Our Ref: EN0110001

Date: 22 September 2025

### **Application by Keadby Next Generation Limited for an order granting development consent for The Keadby Next Generation Power Station Project**

#### **Advice following issue of decision to accept the application for examination**

Drawing file: published-documents / EN0110001-000322-KNGPS 2.18 Indicative Landscape and Biodiversity Plan Rev 1.pdf

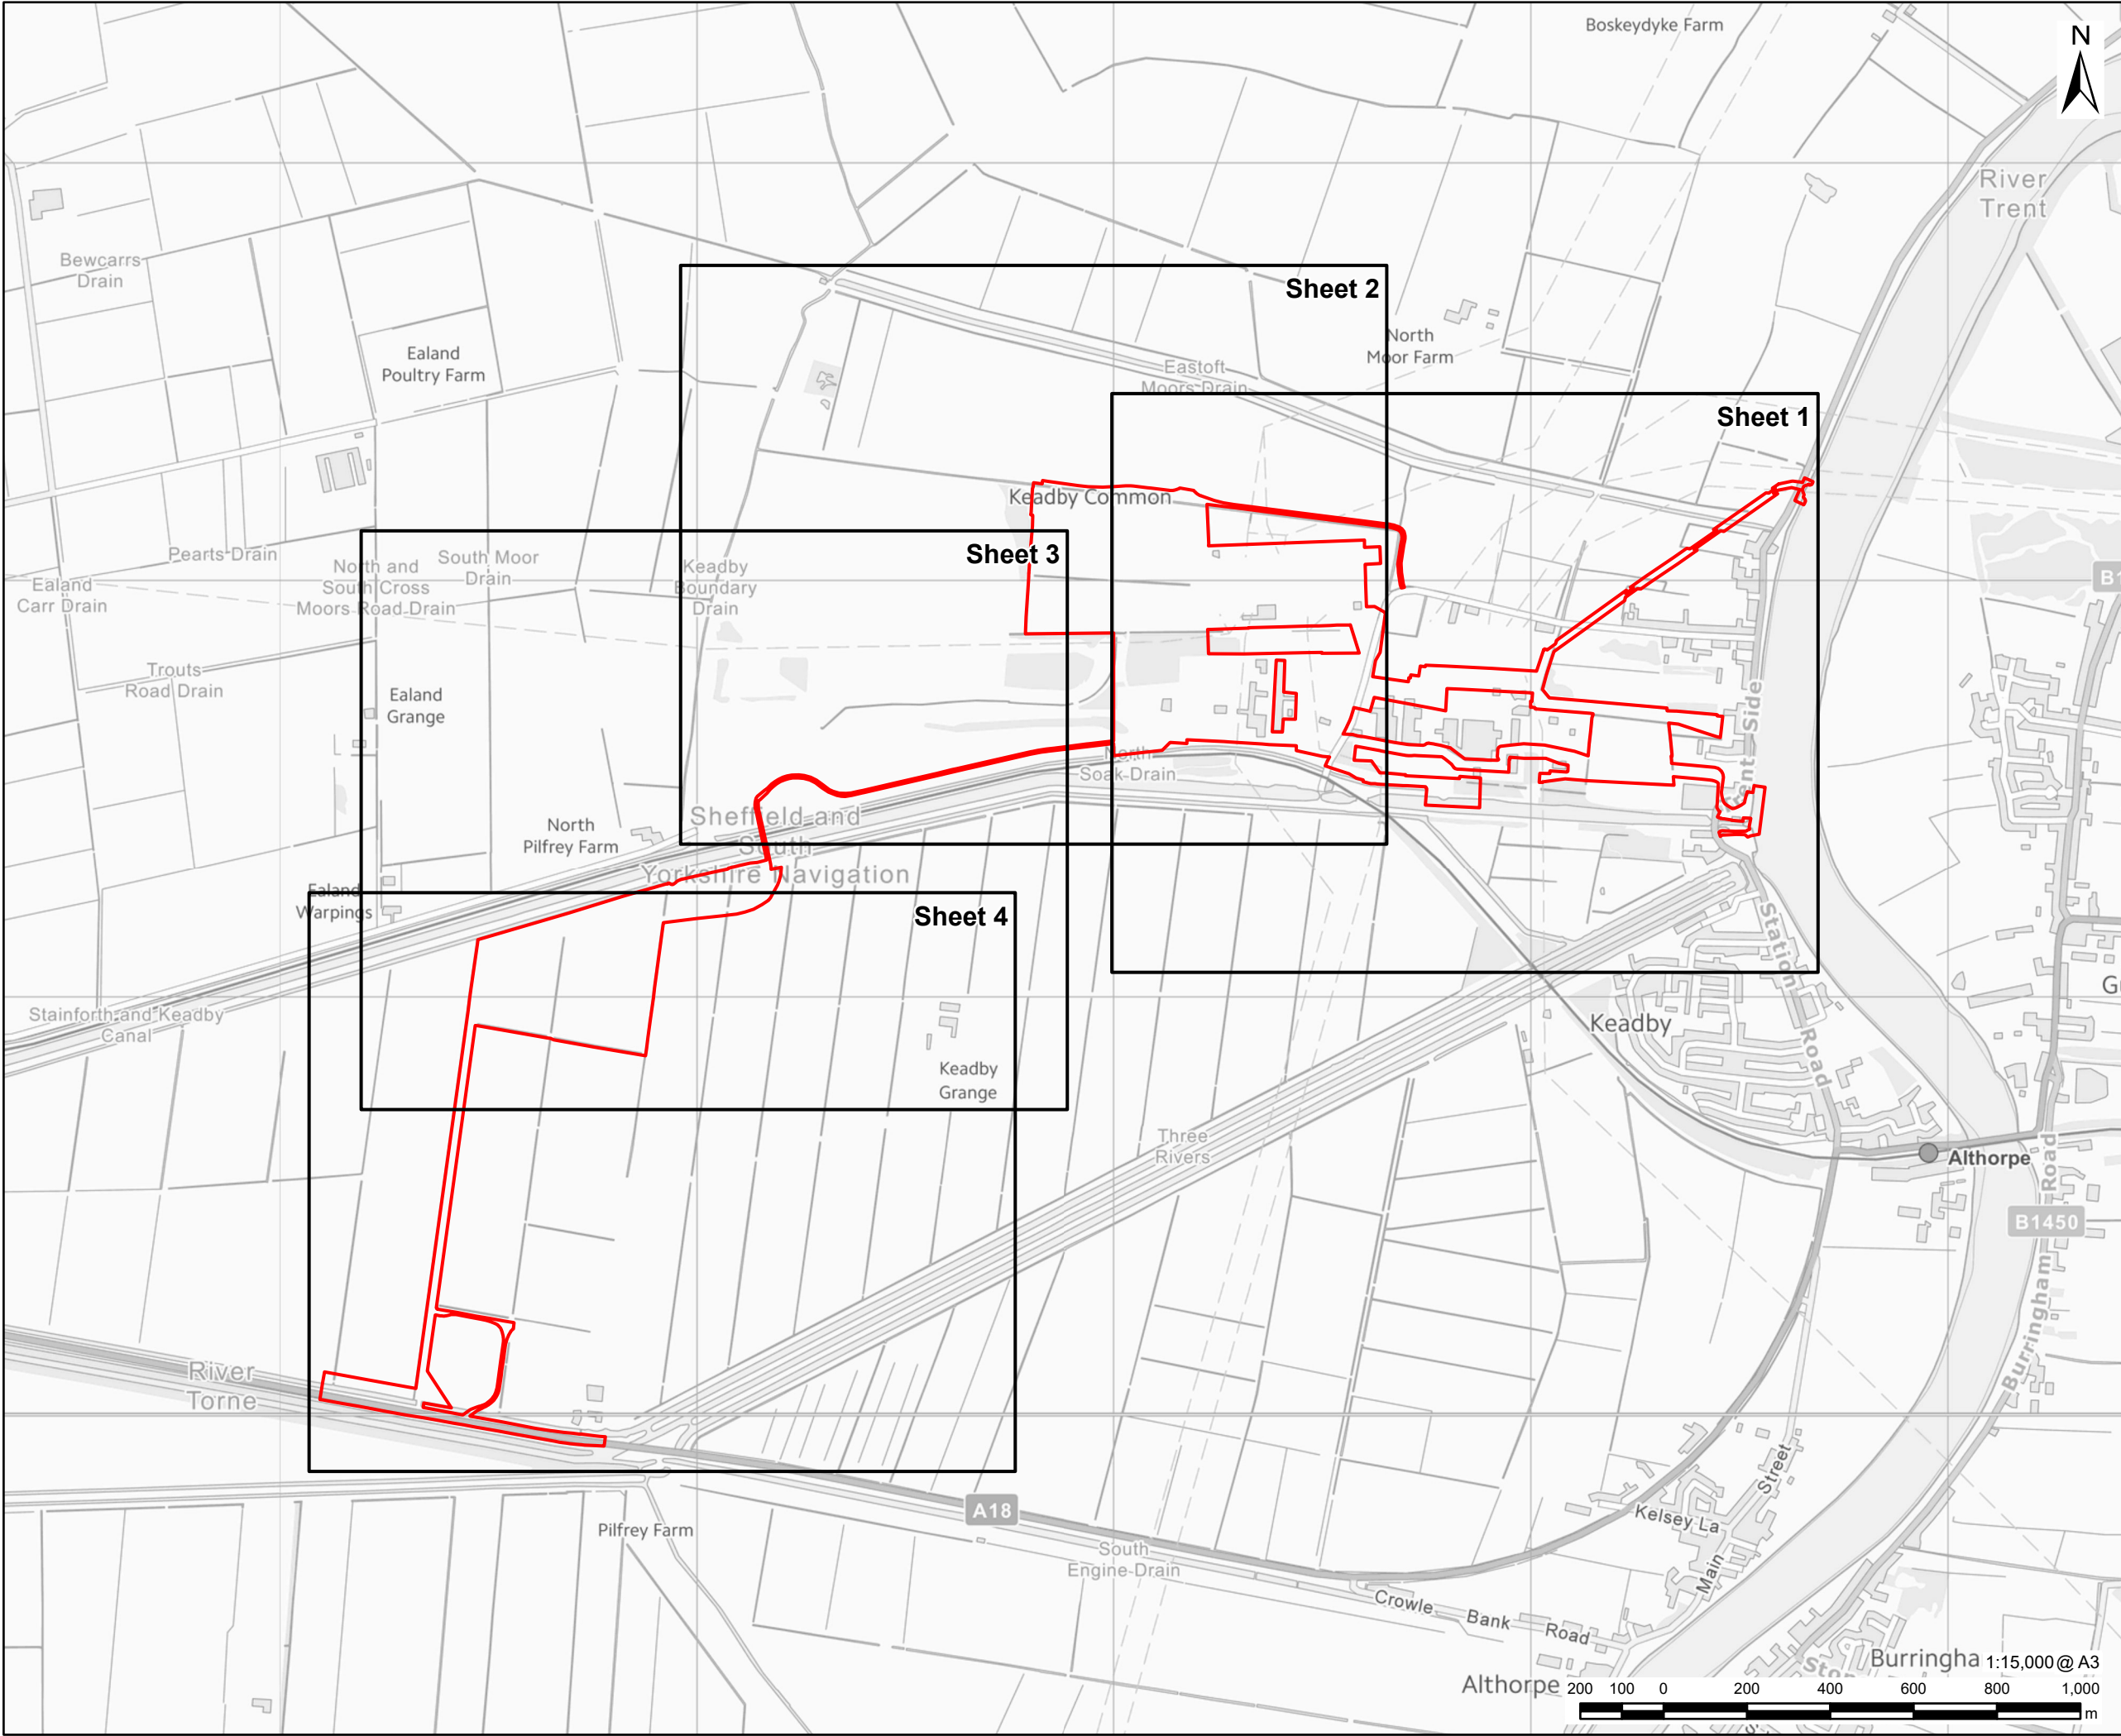
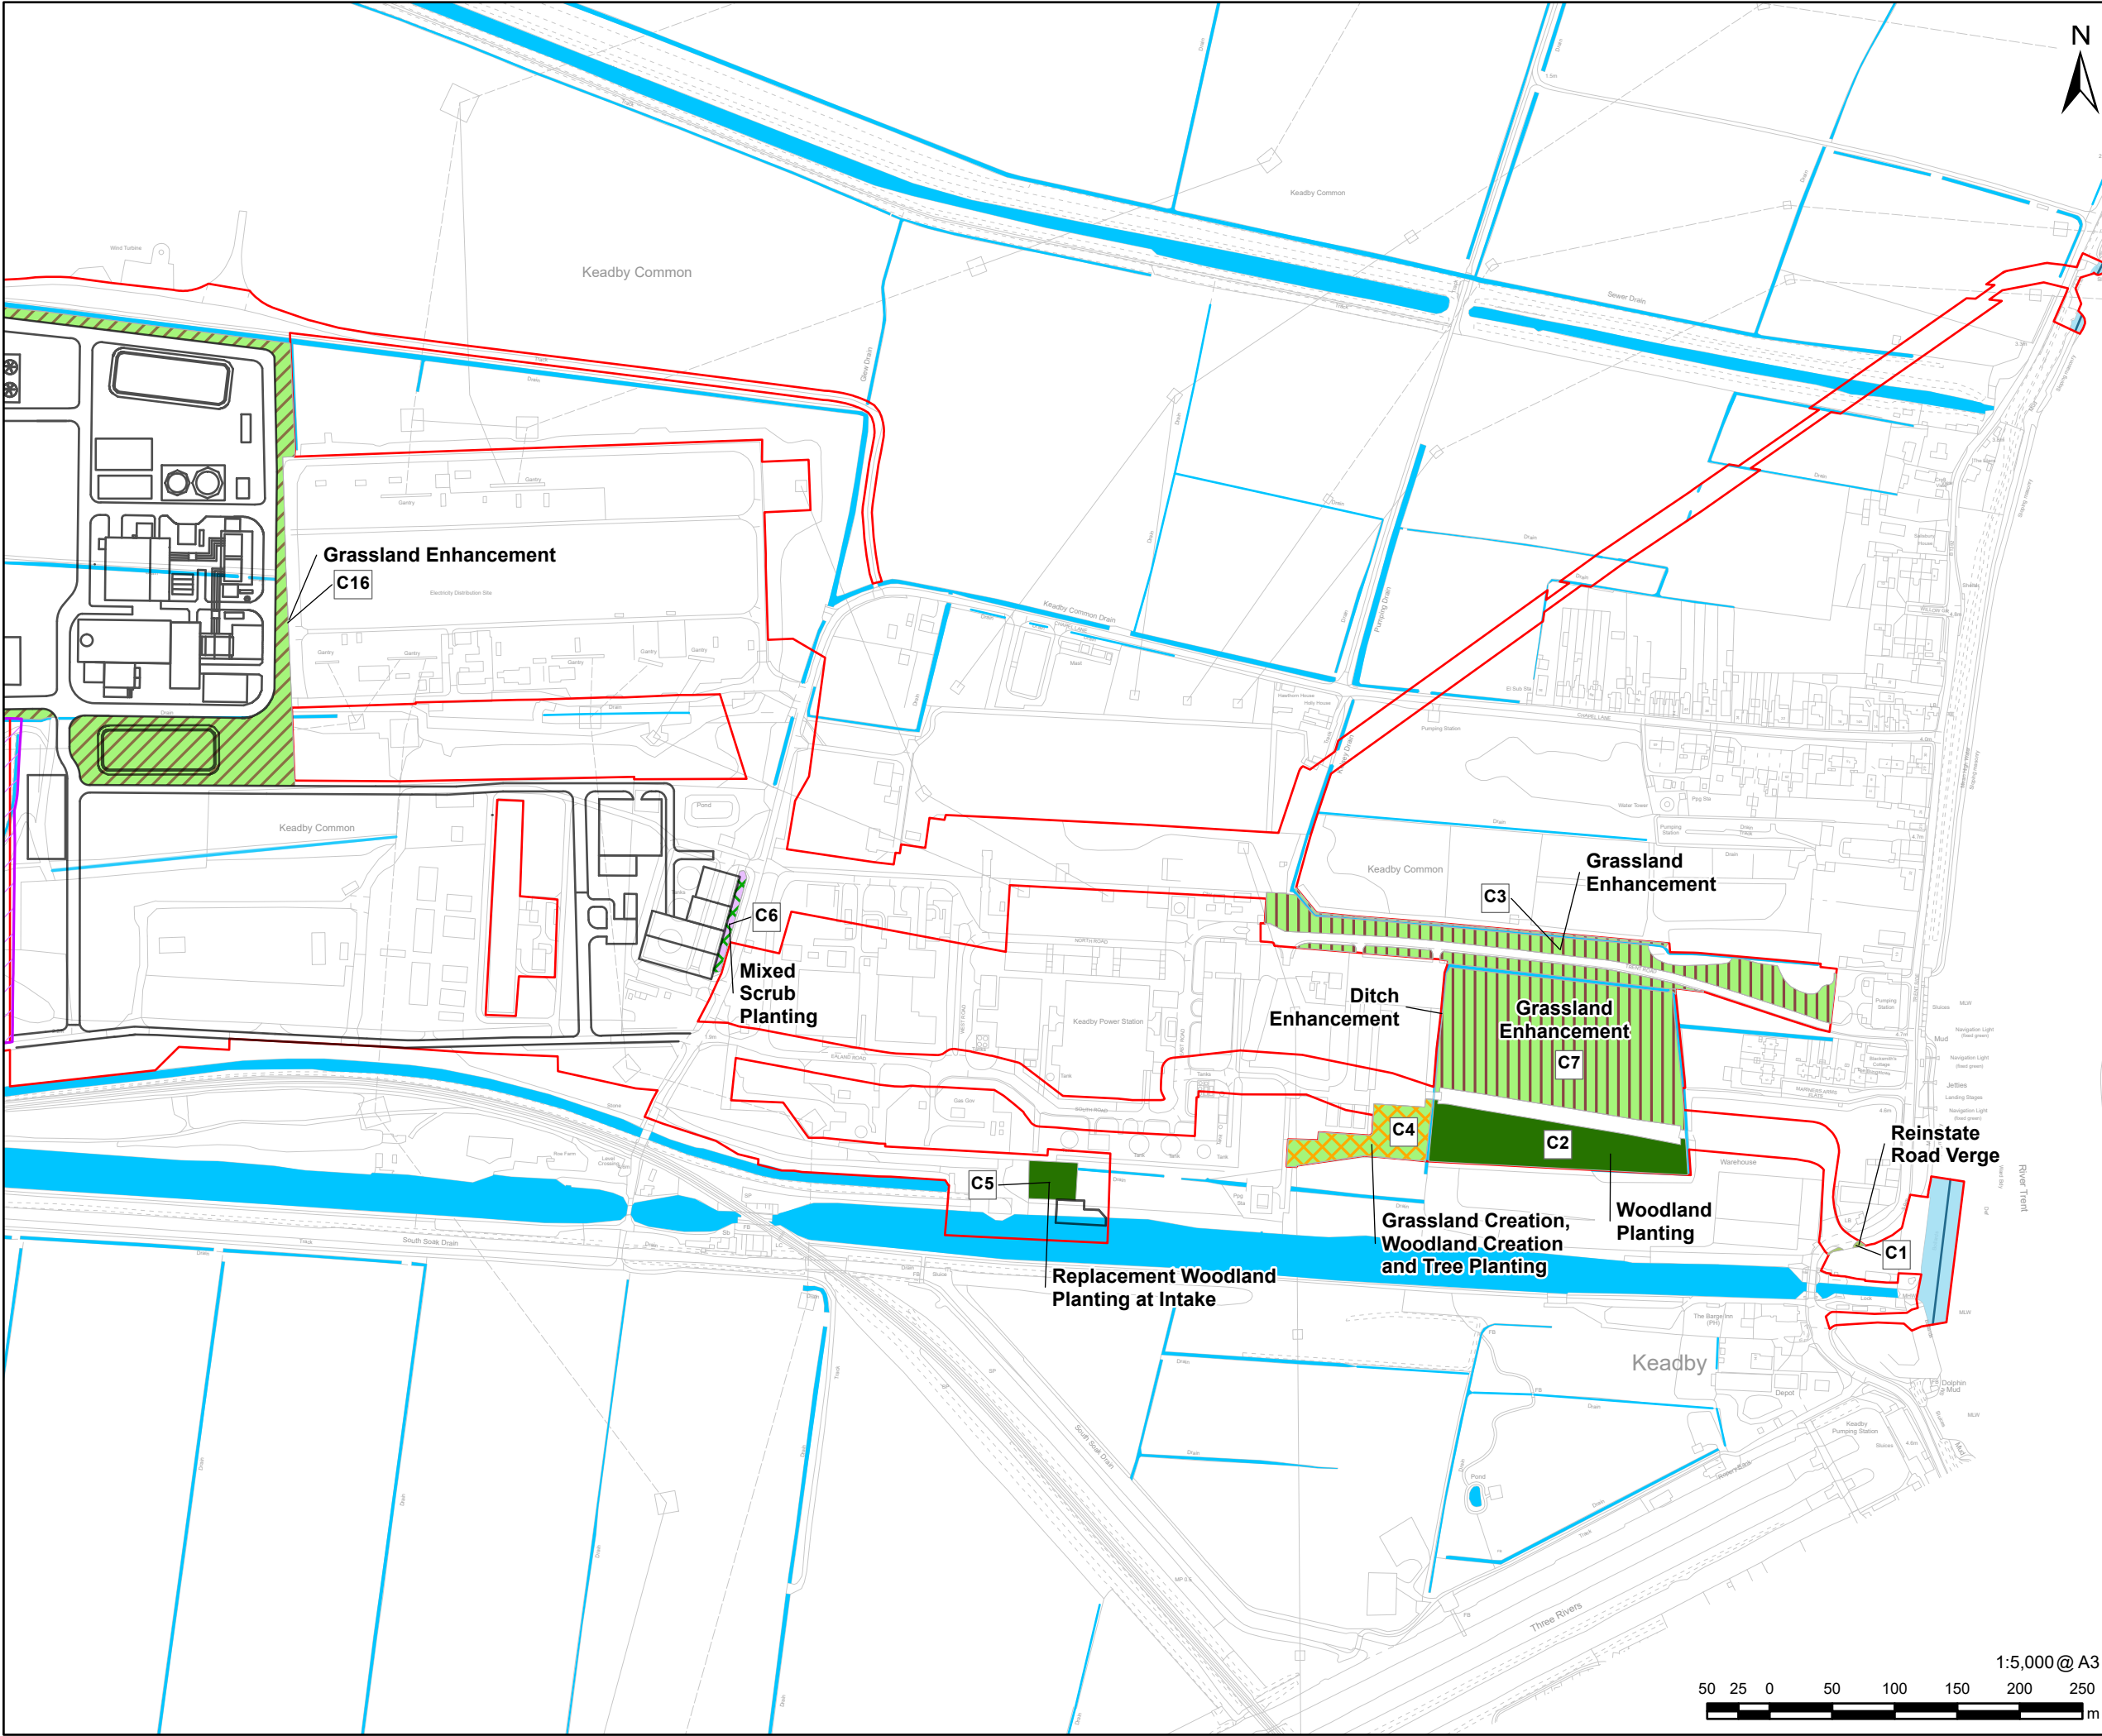
### **Indicative Landscape and Biodiversity Plan (Doc 2.18)**

The plan is missing a key plan. Although it doesn't affect the ability to view or understand the plans, the applicant is advised to amend this. It would be helpful if this could be also be provided at a larger scale.
